Ann Machado - Re: 98 Washington Avenue - Permt #2015-01736

From: Ann Machado <AMACHADO@portlandmaine.gov>
Date: Monday, July 27, 2015 at 5:11 PM
To: Elizabeth Spencer Adams <elizabethspenceradams@gmail.com>
Cc: Philip DiPierro <PD@portlandmaine.gov>
Subject: 98 Washington Avenue - Permt #2015-01736

I have started to review your permit for zoning. I have a few questions/concerns before I can sign off on it.

Basement Floor Plan

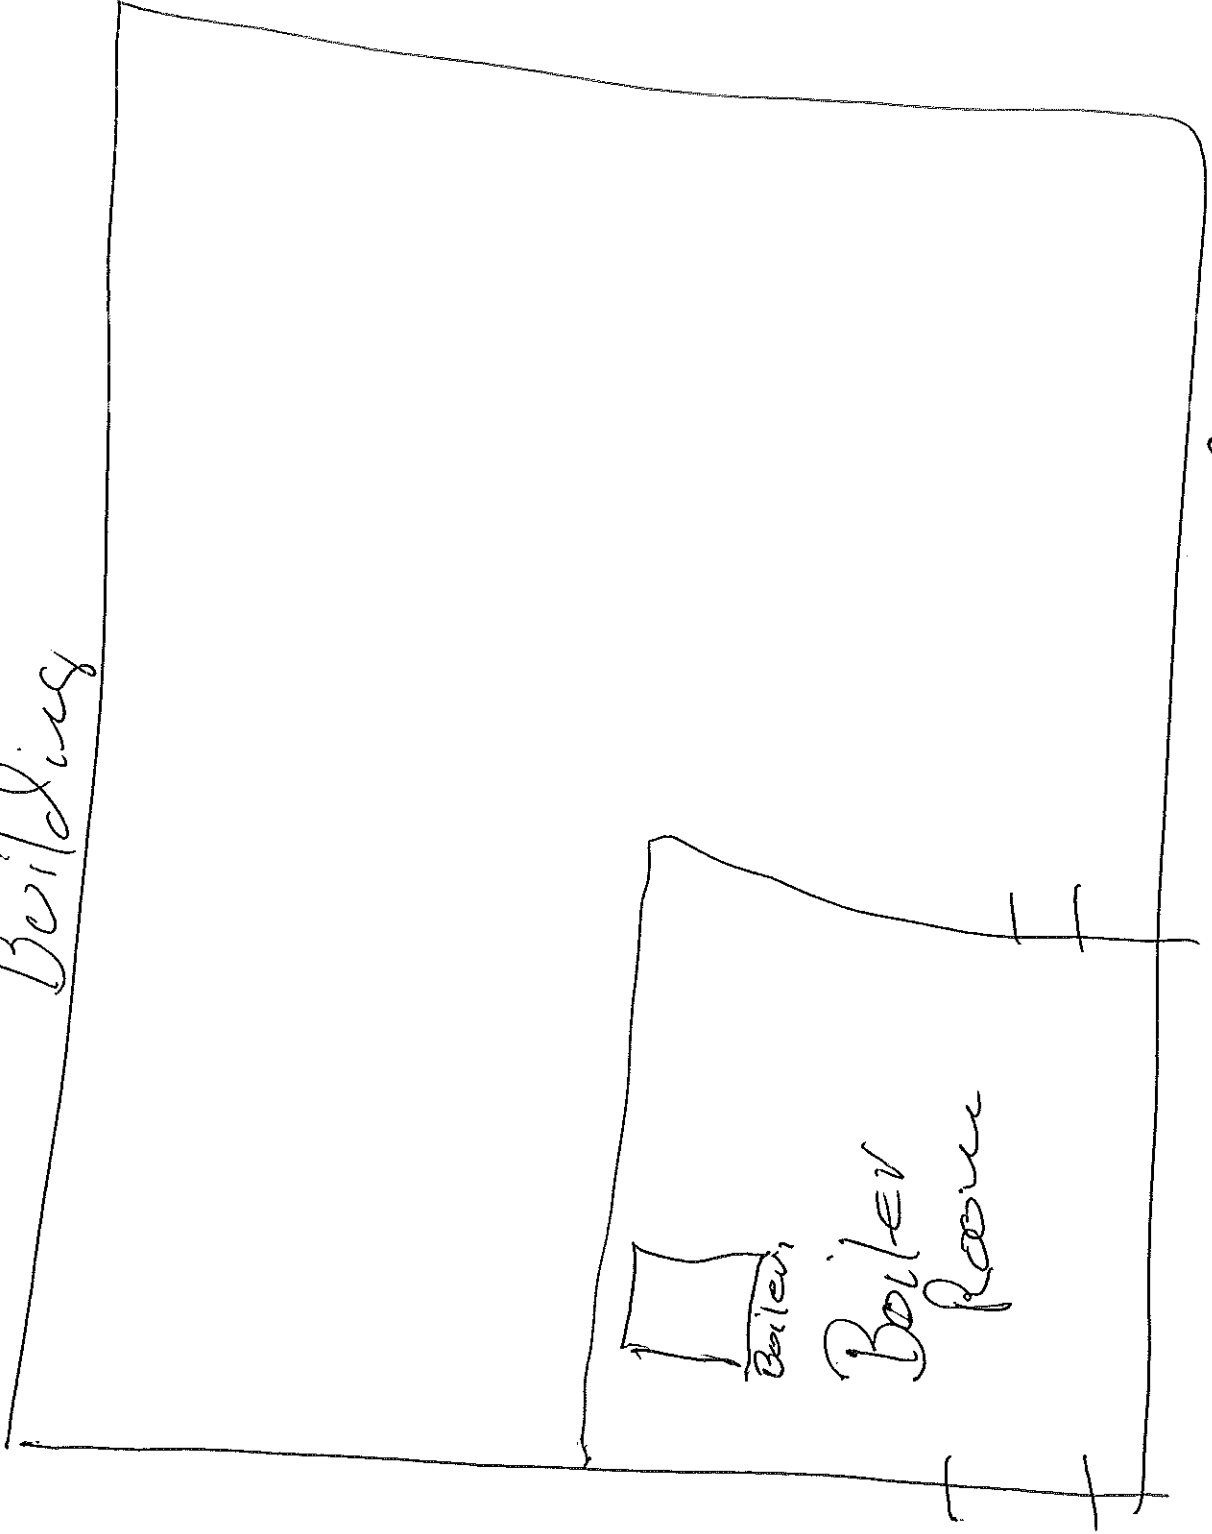
2. Is there a basement? What is located in it?

2. Yes, there is a basement. The inspector and Captain Petrucelli walked through it when they were doing the legalization inspection. (Do you by any chance know the inspector's name? I missed it, but would love to have it for my notes and to be able to address him by name if I meet him again.) There is a utility room with a boiler and hot water heater in the back (away from Washington Ave). We will be adding a washer and dryer and residential tenant storage to that back portion. The front (close to Washington Avenue) is empty and will be used as storage for the first floor front tenant.

98 WASHINGTON AVE
 98 1st Floor Proposed
 (office in rear, food service in front)

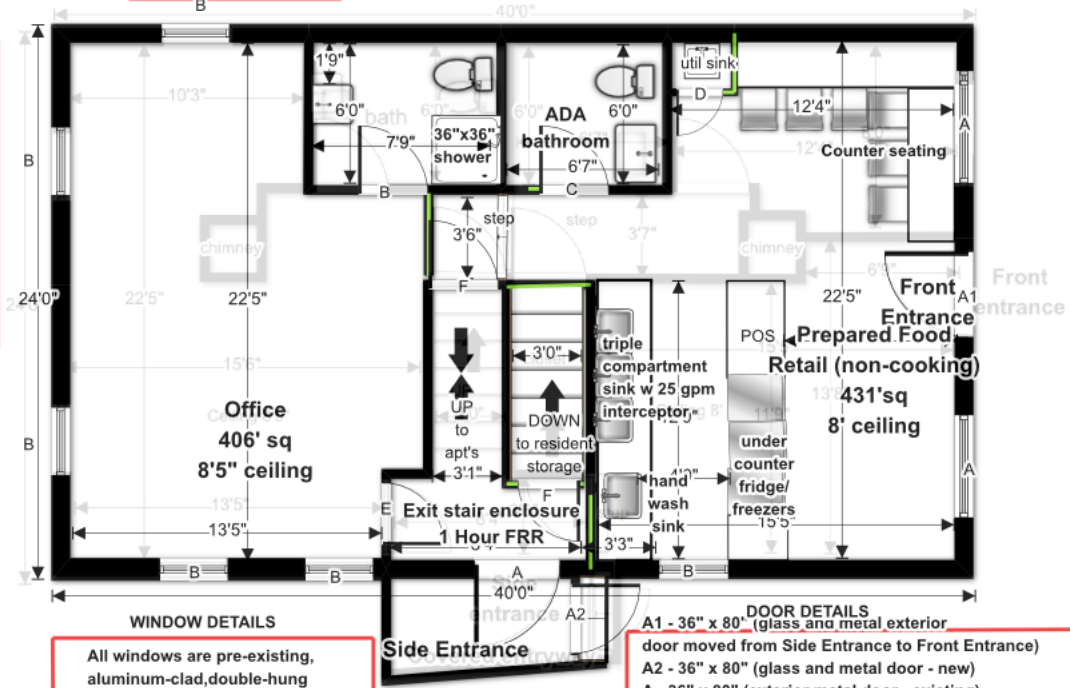
1. Are you establishing a specific use for the first floor front part at this time? If not you will have to apply for a separate permit later to establish the use if it does not remain office use.

1. After consulting with a potential tenant, we have decided to go ahead with development of the front part of the first floor as a cold food retail/service. There will be no cooking. What would you need to see from us beyond the floor plan of the space as developed for this purpose? You had given me the names of Ben Pearson and Mike Russell if we were to have any kind of food prep in the space. I will reach out to them to see what guidance they might be able to give us.

SITE PLAN
98 WASHINGTON AVENUE
 SUBMITTED BY MOUNT JOY LLC

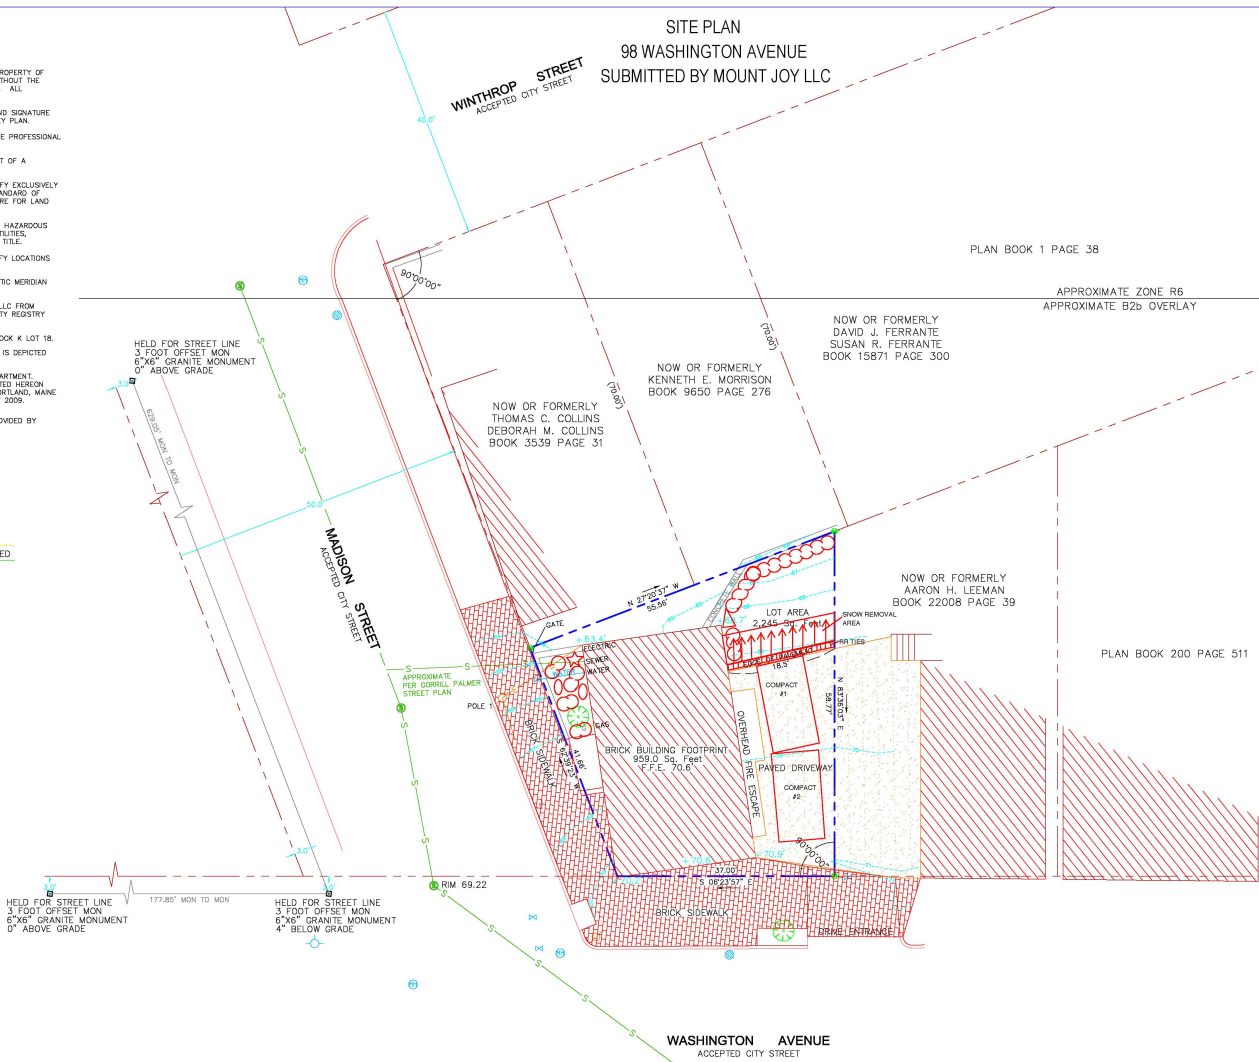
3. You will need to provide two off-street parking spaces for the new units. A parking space is 9' wide by 18' deep. Please indicate the two spaces on the site plan. Before you make changes to the site plan I would wait to see if Phil DiPierro will require any changes to the site plan.

4. It appears from the site plan that to access the parking you have to go across the property that belongs to 102 Washington Avenue. Do you have an easement from the owner to do this?

3. I will wait to see what comments Jean Fraser may have before making changes to the site plan. I am anticipating possibly needing to obtain an easement from Mr. Leeman for a small triangle shaped bit of his side of the driveway to achieve the 9 x 18 dimensional requirement for the second space. It is tight, but very close. If needed, we will include the right to park cars on this triangle of space in the easement to travel over his land to get to our parking spots. (See #4 below.)

4. We are in the process of obtaining an easement from the next door neighbor, Aaron Leeman, regarding crossing his property to access our parking area.
